**Re: McDonald's Menaul**  
**5900 Menaul Blvd. NE**  
**Traffic Circulation Layout**  
Engineer's Stamp 07-07-23 (H18-D070)

Based upon the information provided in your submittal received 07-10-23, the above referenced plan cannot be approved for Building Permit until the following comments are addressed:

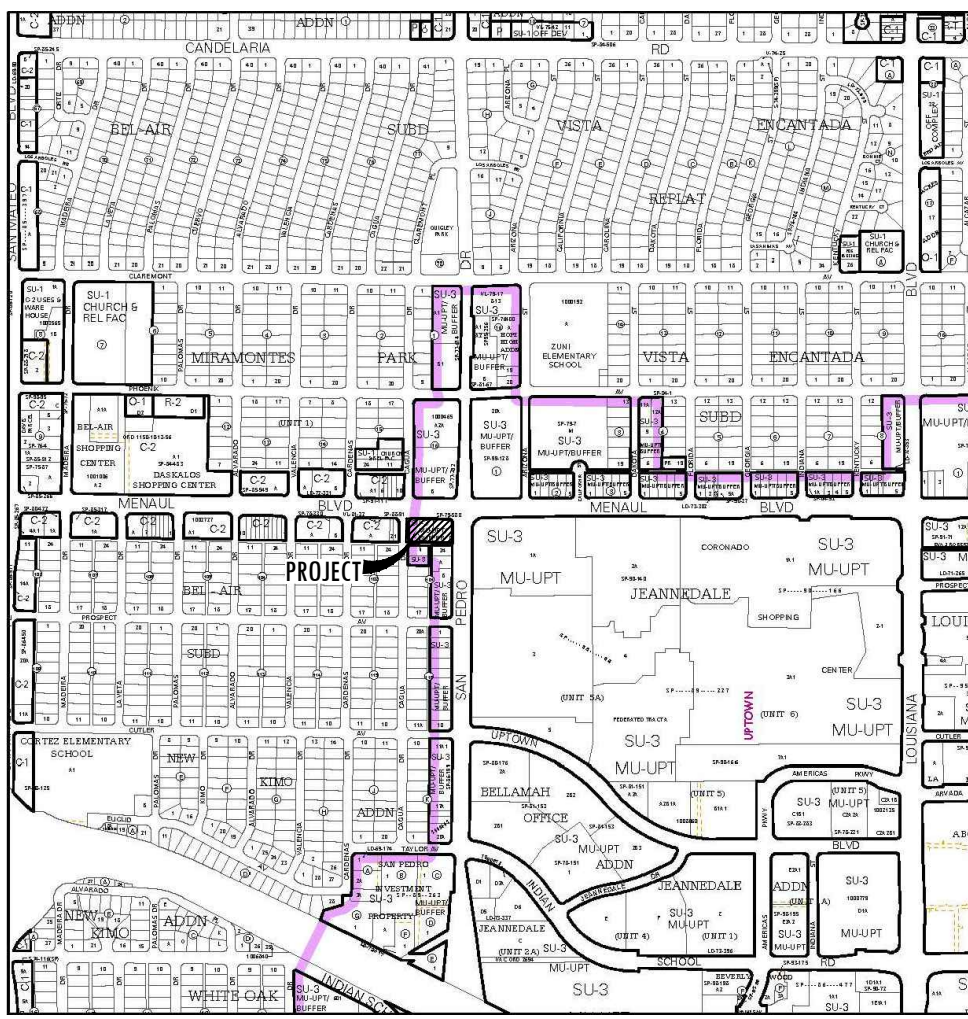
1. Access throat length for the site access driveway off Menaul should be minimum 50 ft. please show this dimension on the site plan.
2. Access throat length for the site access off San Pedro should be minimum 25 ft. please show this dimension on the site plan.

3. Per drive-thru lanes stacking requirements: Please show on the site plan minimum 12 cars stacking in the drive-thru lanes.
4. Details sheet is missing.

5. The ADA accessible parking sign must have the required language per 66-7-352.4C NMSA 1978 **"Violators Are Subject to a Fine and/or Towing."** Please call out detail and location of signs.

6. Motorcycle parking spaces shall be designated by its own conspicuously posted upright sign, either free-standing or wall mounted per the zoning code.

7. The pavement marking "MC" should be shown in the opposite direction for motorcycles entering the parking space.
8. All bicycle racks shall be designed according to the following guidelines:

10. A 1-foot clear zone around the bicycle parking stall shall be provided.
11. Bicycle parking spaces shall be at least 6 feet long and 2 feet wide.
12. Keynote 28: all stall striping should be in white.
13. Refuse vehicle maneuvering shall be contained on-site. The refuse vehicle shall not back into the public right of way.; provide a copy of refuse approval.
14. Provide a copy of Fire Marshal approval.
15. Please show on the site plan these lane widths.

16. All one-way drives shall have "One Way" and "Do Not Enter" signage and pavement markings. Please show detail and location of posted signs and striping.

17. The minimum drive through lane width is 12 feet with a 25-foot minimum radius (inside edge) for all turns. (A 15-foot radius can be used with an increase in lane width to 14 feet). Please dimension all lane widths and radii.

18. Show the clear sight triangle and add the following note to the plan: "Landscaping and signage will not interfere with clear sight requirements. Therefore, signs, walls, trees, and shrubbery between 3 and 8 feet tall (as measured from the gutter pan) will not be acceptable in the clear sight triangle.

19. Please specify the City Standard Drawing Number when applicable.
20. Unused curb cuts must be replaced with sidewalk and curb & gutter. A build note must be provided referring to the appropriate City Standard drawing.

21. Add a note stating "All broken or cracked sidewalk must be replaced with sidewalk and curb & gutter." A build note must be provided referring to the appropriate City Standard drawing.
